CITY OF ALBUQUERQUE

**Re: Lot 25-A, Block J, Lavaland Addition
Request Permanent C.O. - Accepted
Engineer's Stamp dated: 8-4-13 (K12D082)
Certification dated: 9-25-14**

RE: LOT 26-A, BLOCK J, LAVALAND ADDITION
FINAL CERTIFICATE OF OCCUPANCY (K-11/D082)

Re: **Lot 26-A, Block J, Lavaland Addition**
Grading and Drainage Plan for Building Permit

DRAWING:	DRAWN BY:	DATE:	SHEET #
201314-GR.DWG	SH-B	05-29-2013	1

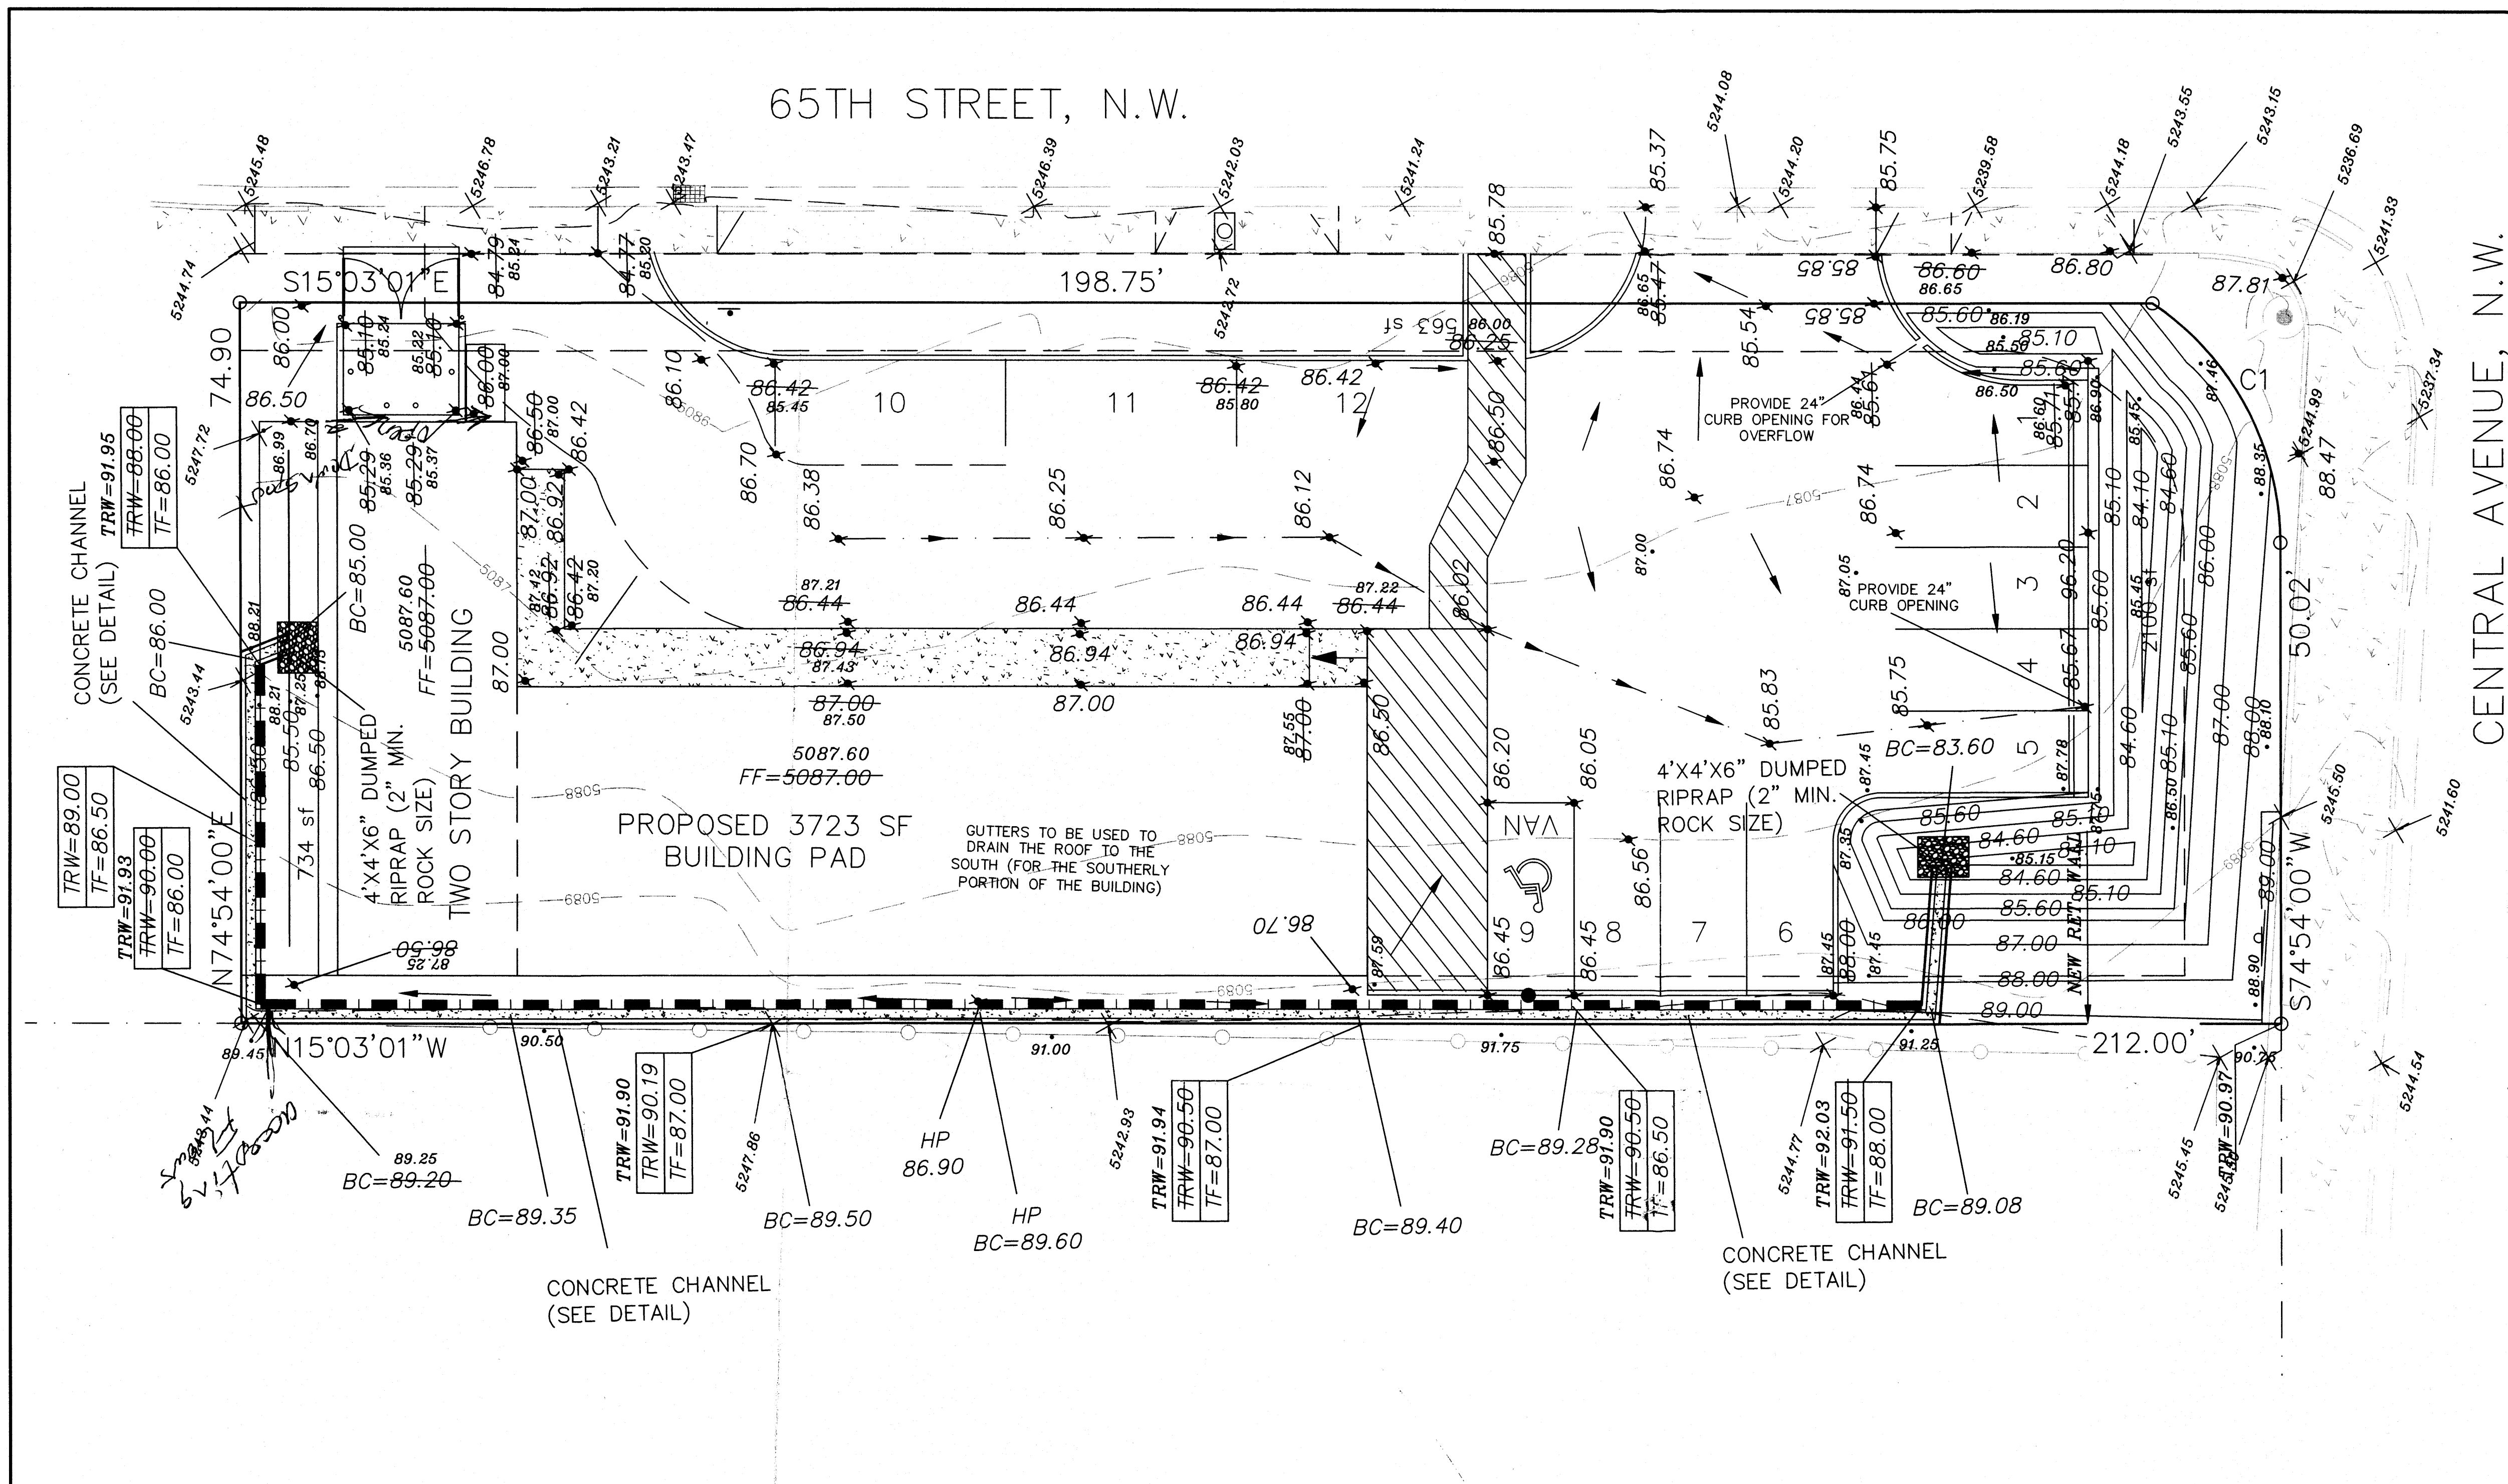
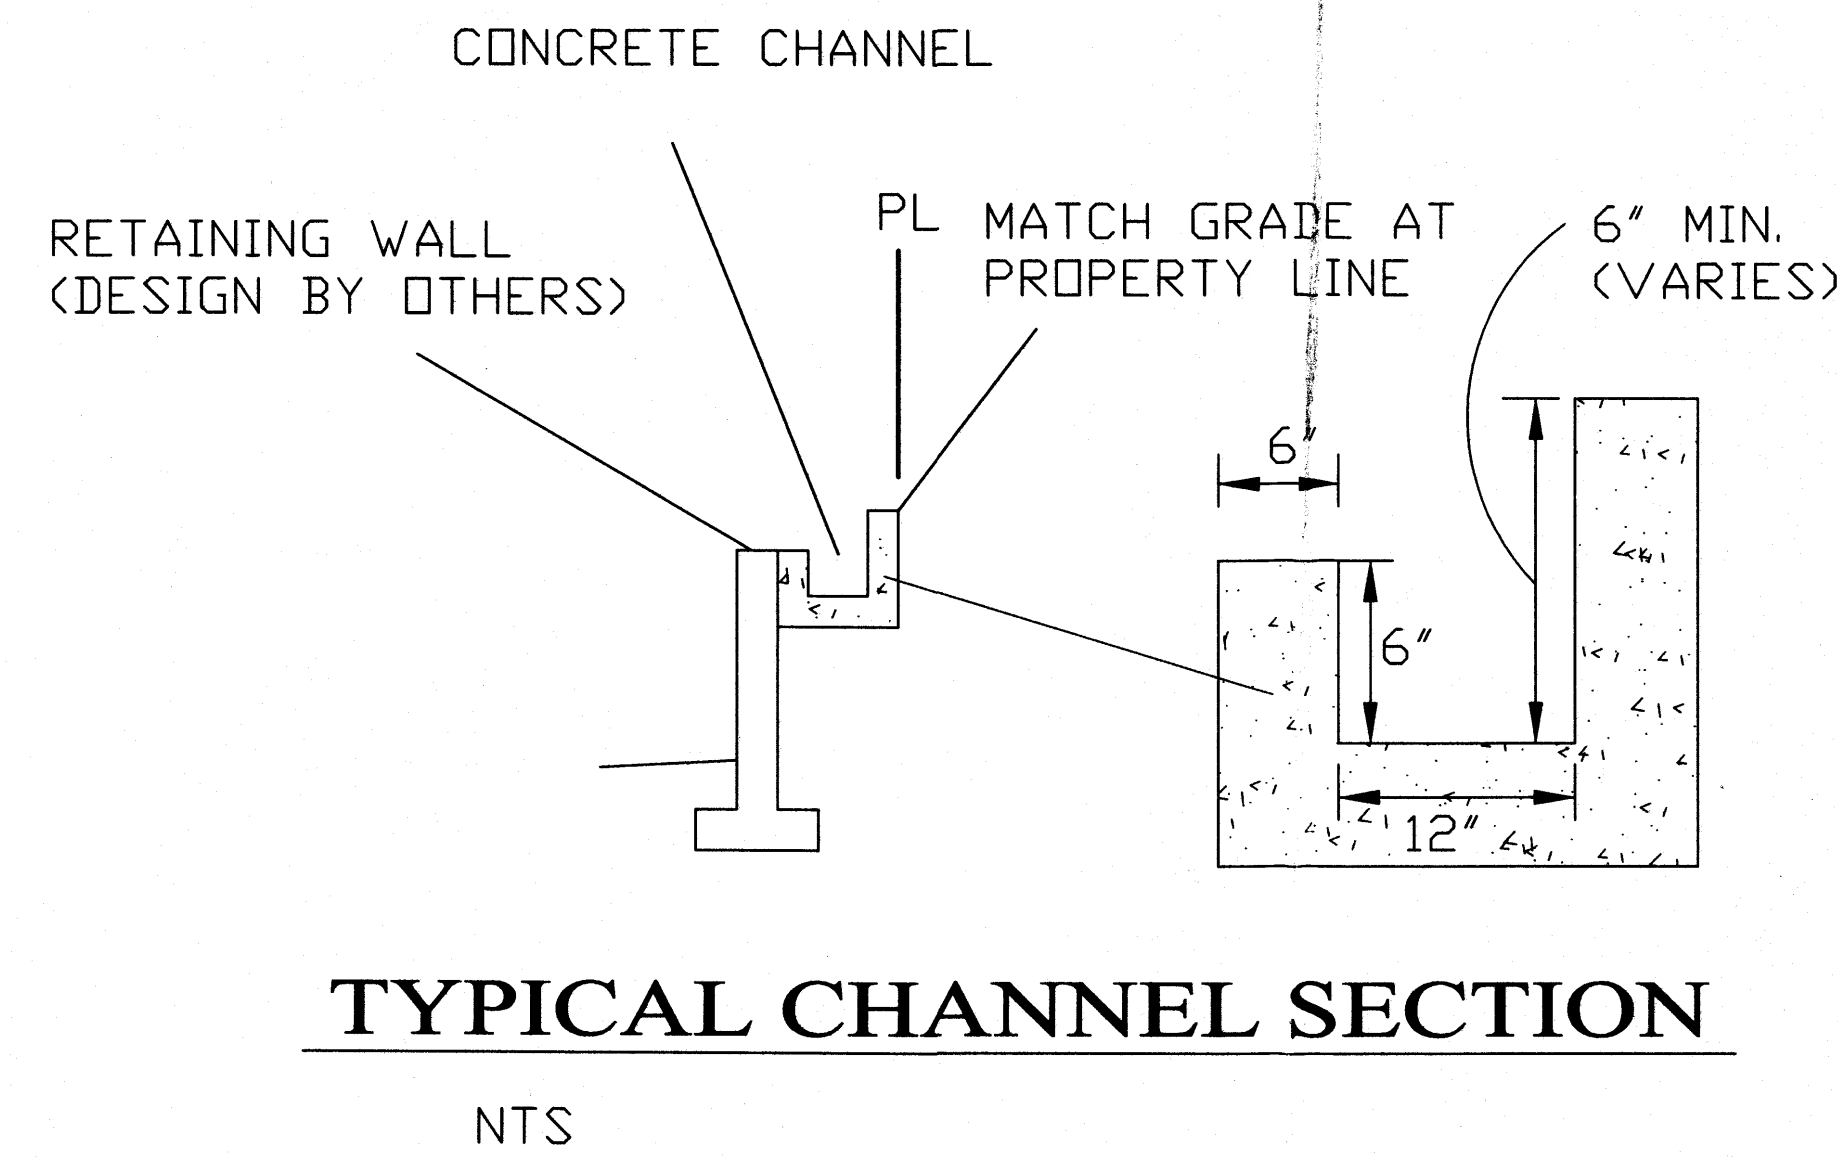
Please attach a copy of this approved plan to the construction sets when submitting for a Building Permit. I acknowledge the handwritten note on this plan, near the NE corner of the site, which clarifies that the entrance curb will be aligned per the site plan. Please show the as-built configuration on your Grading Certification Plan.

- Provide additional spot elevations along the back-of-sidewalk just north of the proposed detention pond.
- Include drainage calculations for the two 12" curb openings. Hydrology suggests that they be widened to 24" to accommodate drainage flows from the pond.
- Show the water surface elevation on the grading plan.
- Correct the legend to reflect the displayed hash lines for the existing retaining wall.
- A site visit identified significant offsite flows from the parcels west and northwest of the site. Determine and show the extent and quantity of offsite flows and provide design details for conveying those flows through this site.
- Correct the "Existing Drainage Conditions" of the narrative to reflect the presence of an existing garden wall to the north of the site. No runoff is received at this location but significant runoff does enter the site from the existing car lot to the west.

The offsite runoff will continue to drain through this site. The offsite runoff will enter a 12" concrete channel and then will discharge to the two ponds located to the north and south side of the project. From there the runoff will flow to 65th Street. Small portion of the onsite runoff will drain to the proposed pond to the north, and once the pond capacity is exceeded it will over flow to 65th Street. Most of the onsite runoff will surface flow to a pond to the south of the project, once the pond capacity is exceeded it will overflow to 65th street. The remaining portion of the site will surface flow to 65th Street. The northerly and southerly ponds are designed to retain the developed runoff volume (0.050 ac-ft) minus the existing conditions runoff volume (0.029 ac-ft). Therefore, total ponding volume provided is equal or greater than 0.021 ac-ft.
